CITY OF ALBUQUERQUE

July 29, 2021

**RE: Sonta Trails Unit 4 Apartments
Grading Plans and Drainage Report
Engineer's Stamp Date: 06/03/21
Hydrology File: C10D001A**

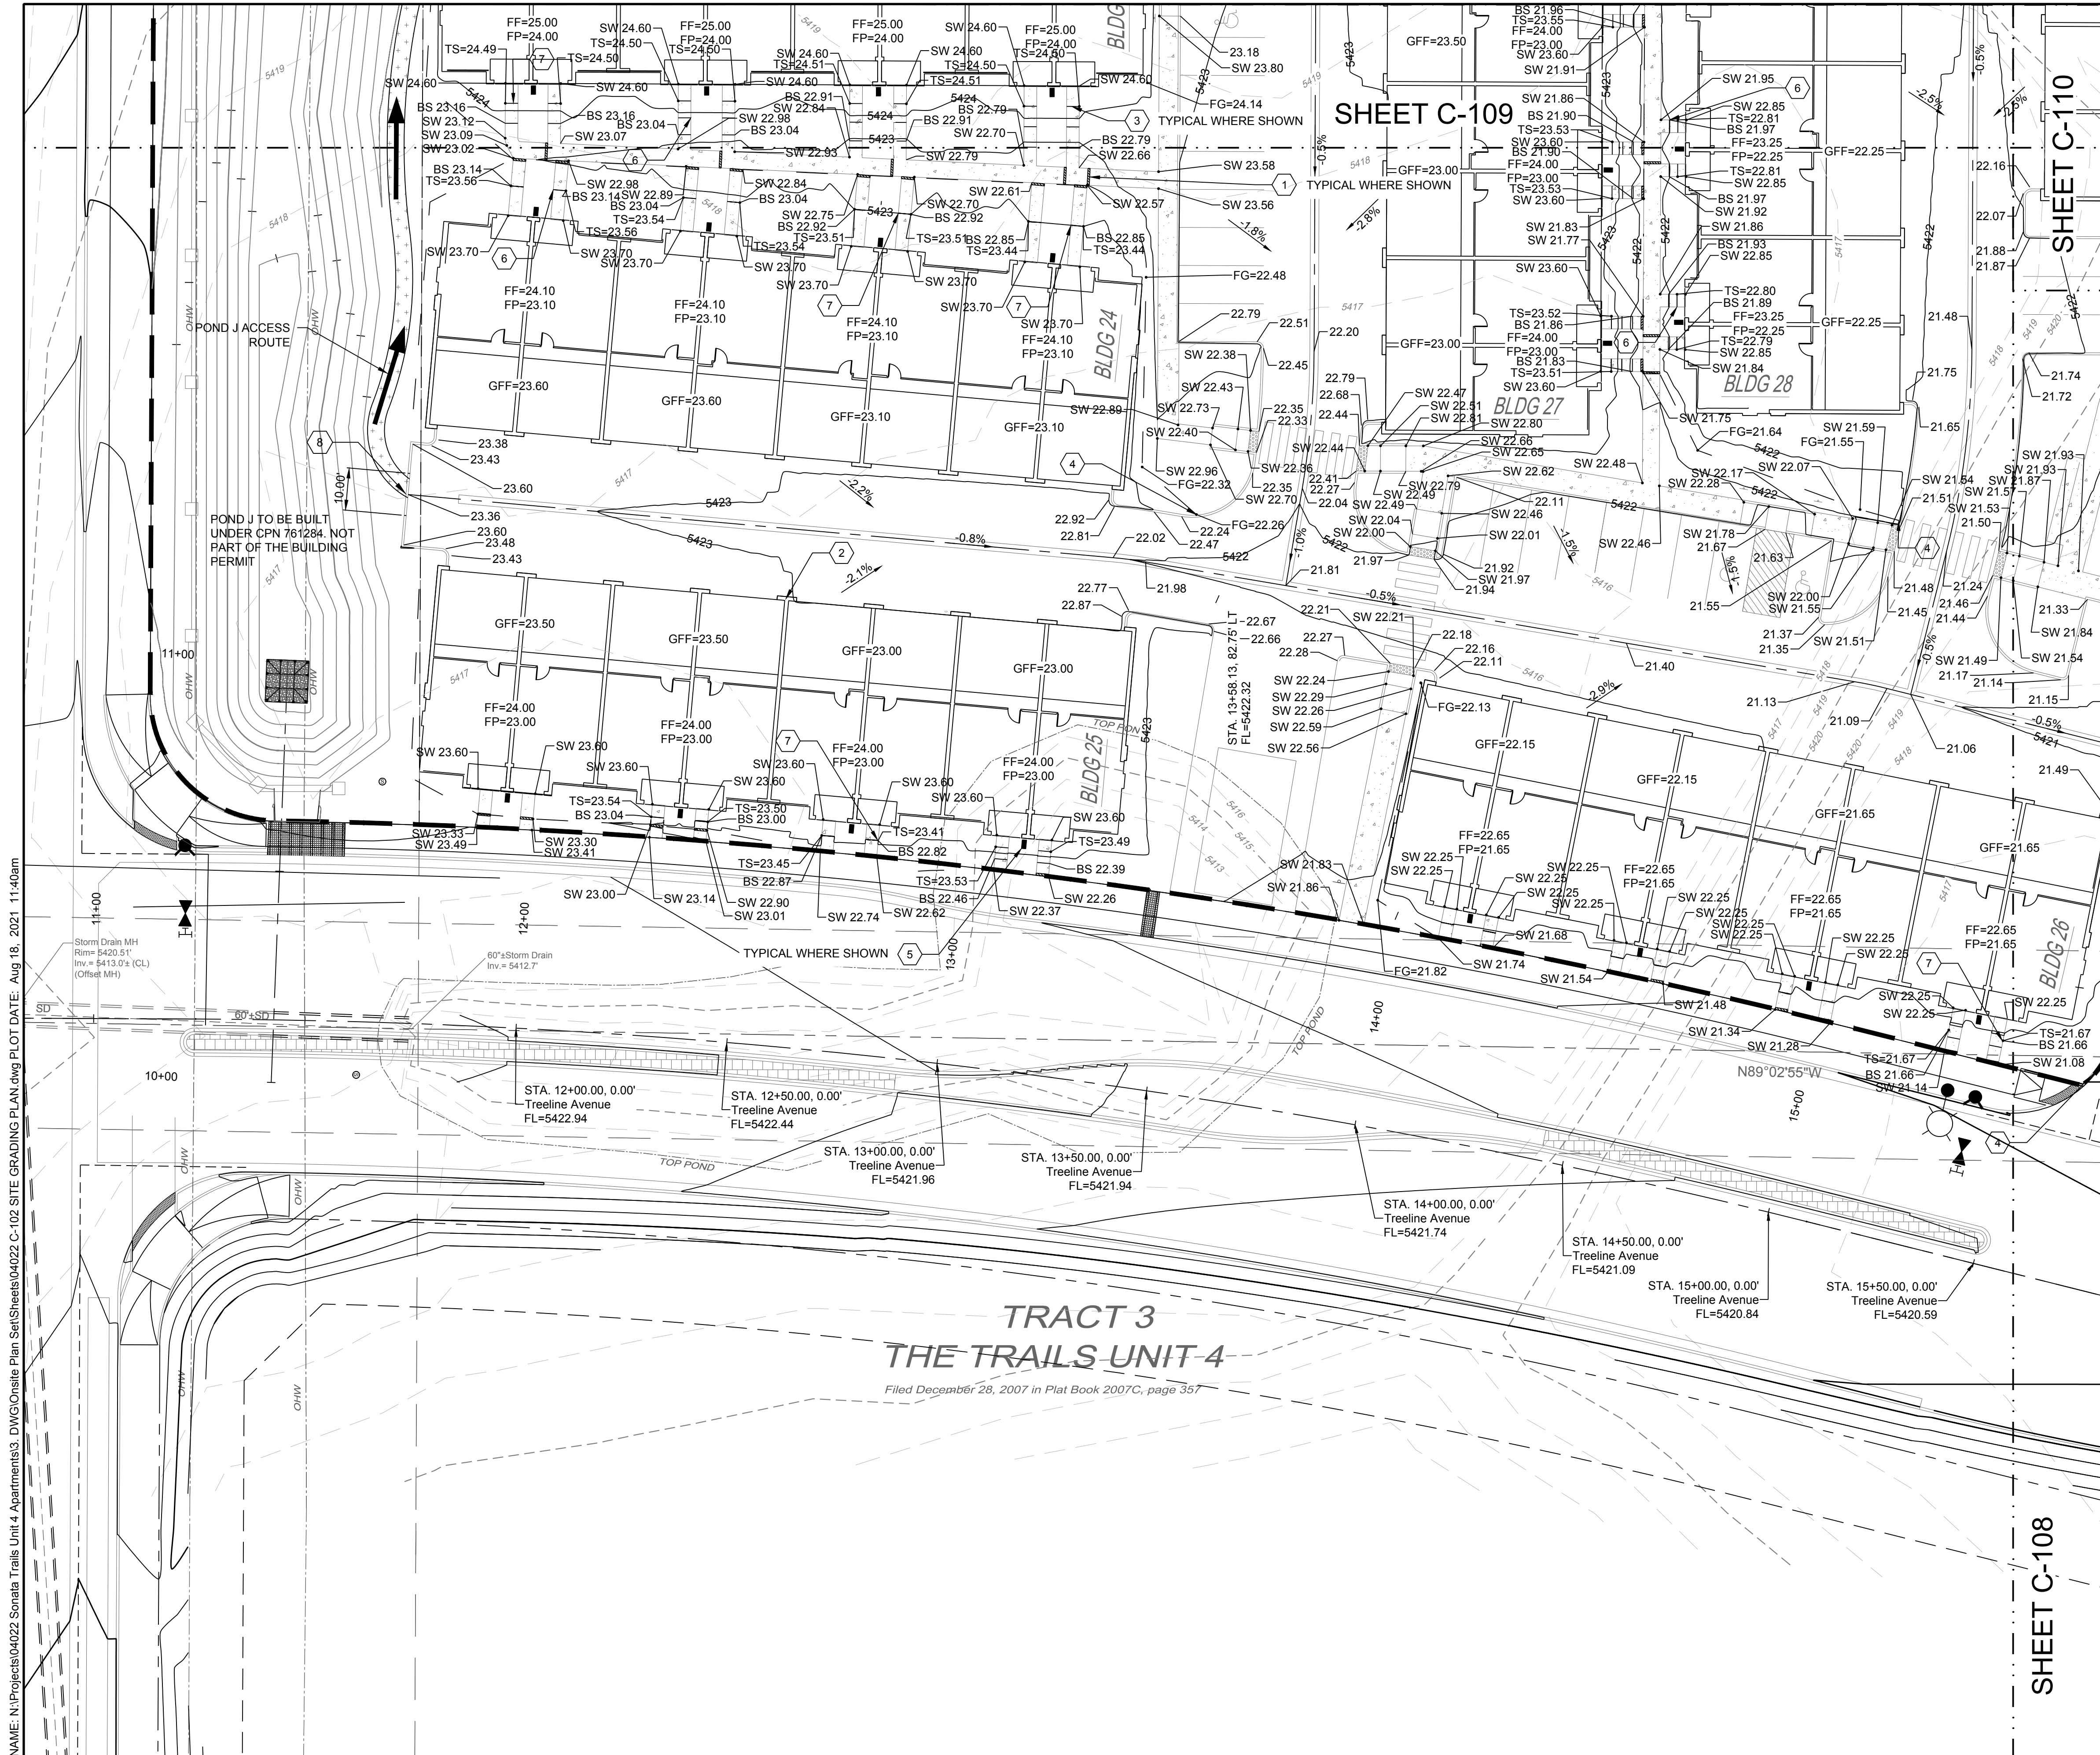
1. Sheet C-107. Please remove the “Preliminary Not for Construction” note.
2. Sheet C-107 & C-109. Please ghost “Pond J” and add a note, “To be built under CPN 761284. Not part of the Building Permit.”
3. Sheet C-107 & C-109. It appears that there will be some sort of fence or wall along Pond J on Universe. Please insure that this fence or wall is outside of the top of pond. One foot distance would be preferred.
4. Sheet C-112. Please remove sheet. Public Retention Pond is to be constructed under CPN 761284 and is not part of the Building Permit.
